**Re:** 25-FRM-155  
Framing Deviation  
Lot 39 Tobacco Road  
108 Golden Leaf Farms Rd.  
Angier, NC 27501  
Permit No.: SFD2505-0049

At your request, a site visit was made to the above referenced single family residence under construction to address framing deviations between the approved plans and roof truss layout.

**Revised 8/5/2025**

**2.01F**  
First Floor Framing Plan  
Elevation "A"

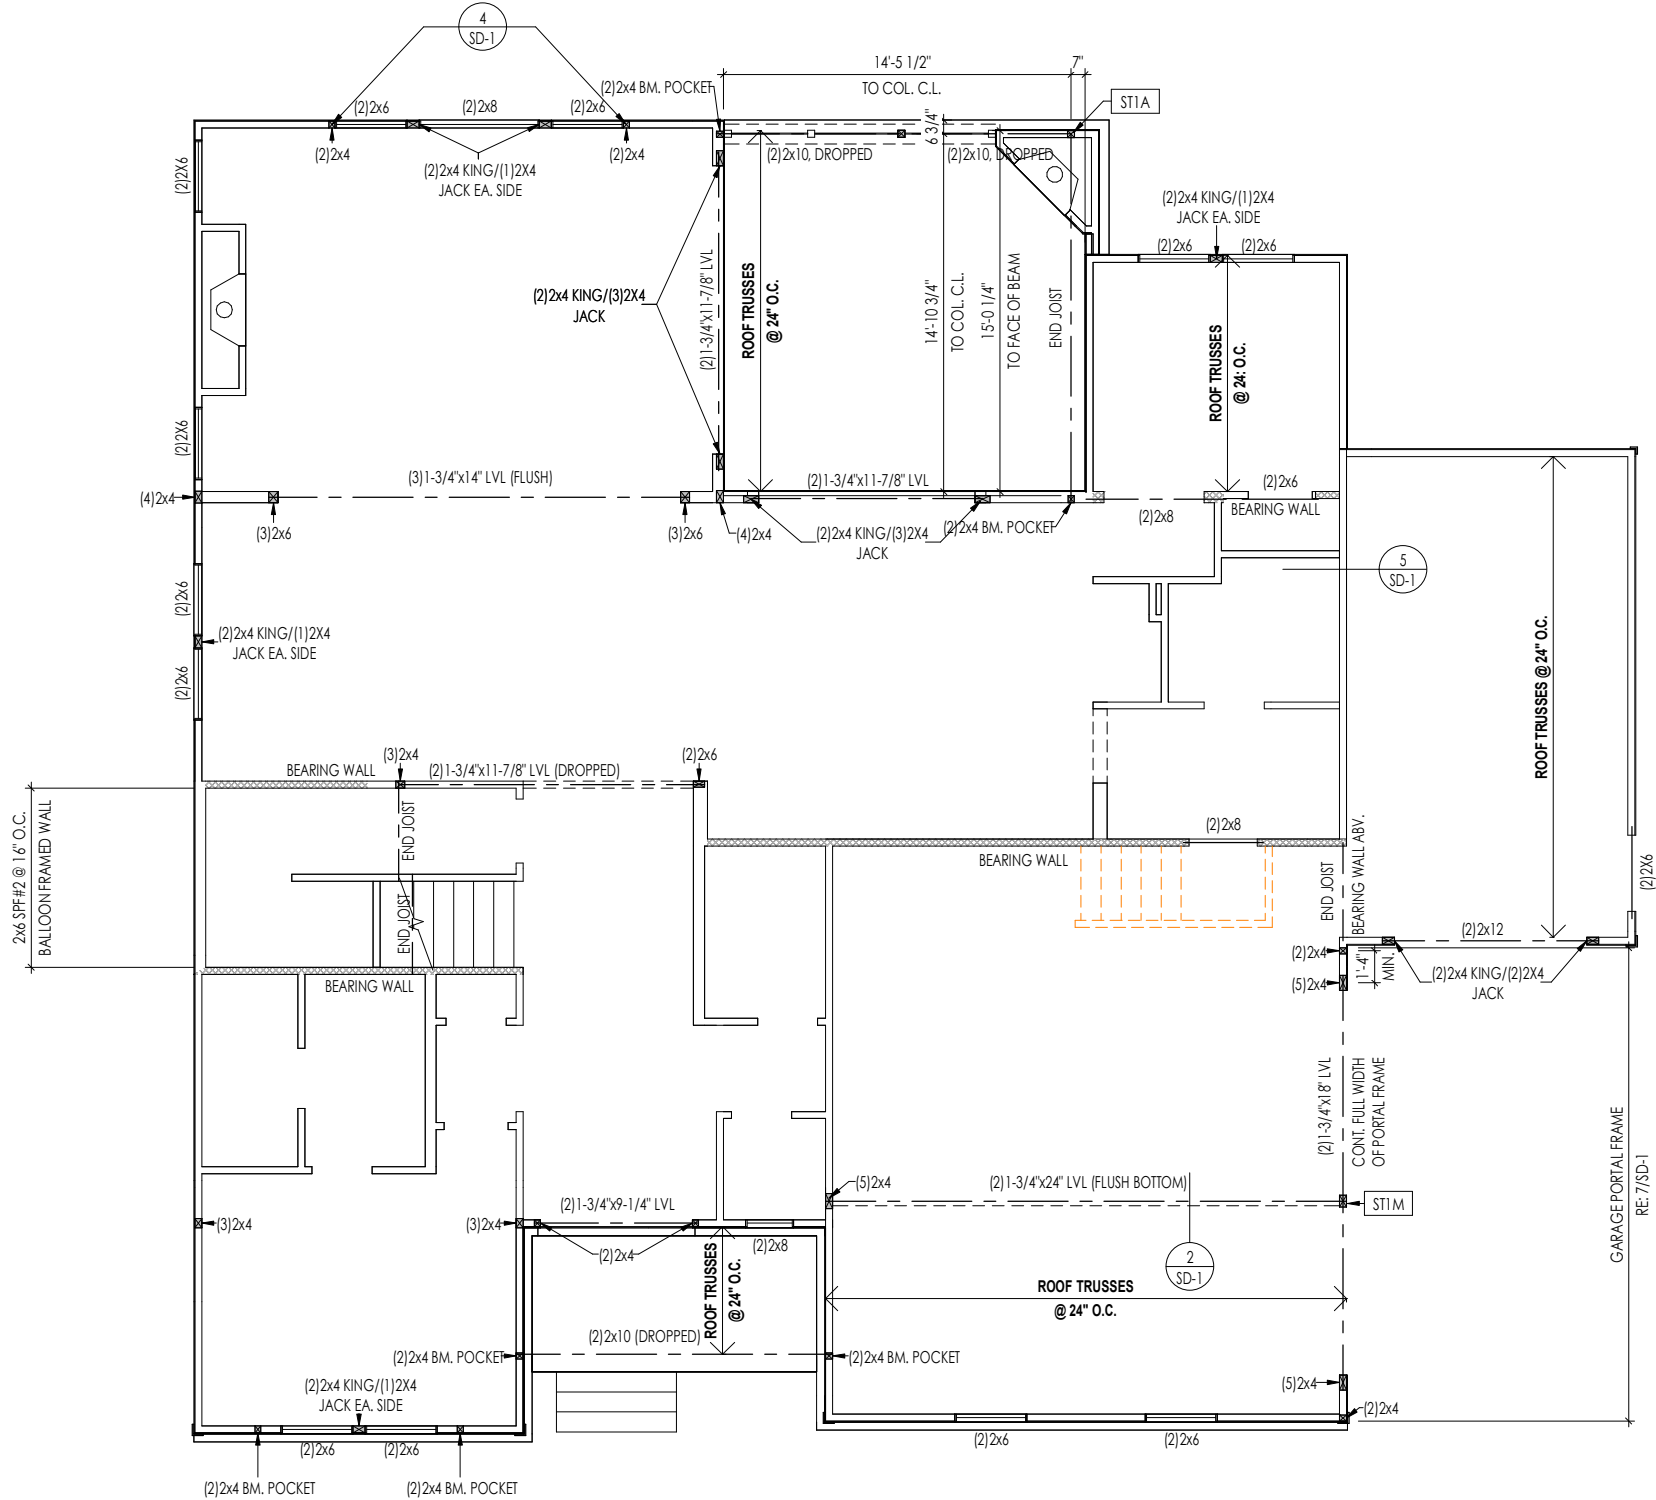
The "end joist" specified above the rear porch in the approved plans was omitted. The roof above the rear porch is constructed with engineered roof trusses.

The plan specified "end joist" is not required. The 4x4 post and the (2) 2x4 beam pocket specified at each end of the "end joist" may be omitted. The porch headers are supported at the right rear corner with (3) 2x4 studs. Install a Simpson Strong-Tie L70 angle in the right rear corner between the porch headers.

These prescribed framing modifications will provide the required support for all imposed loads.
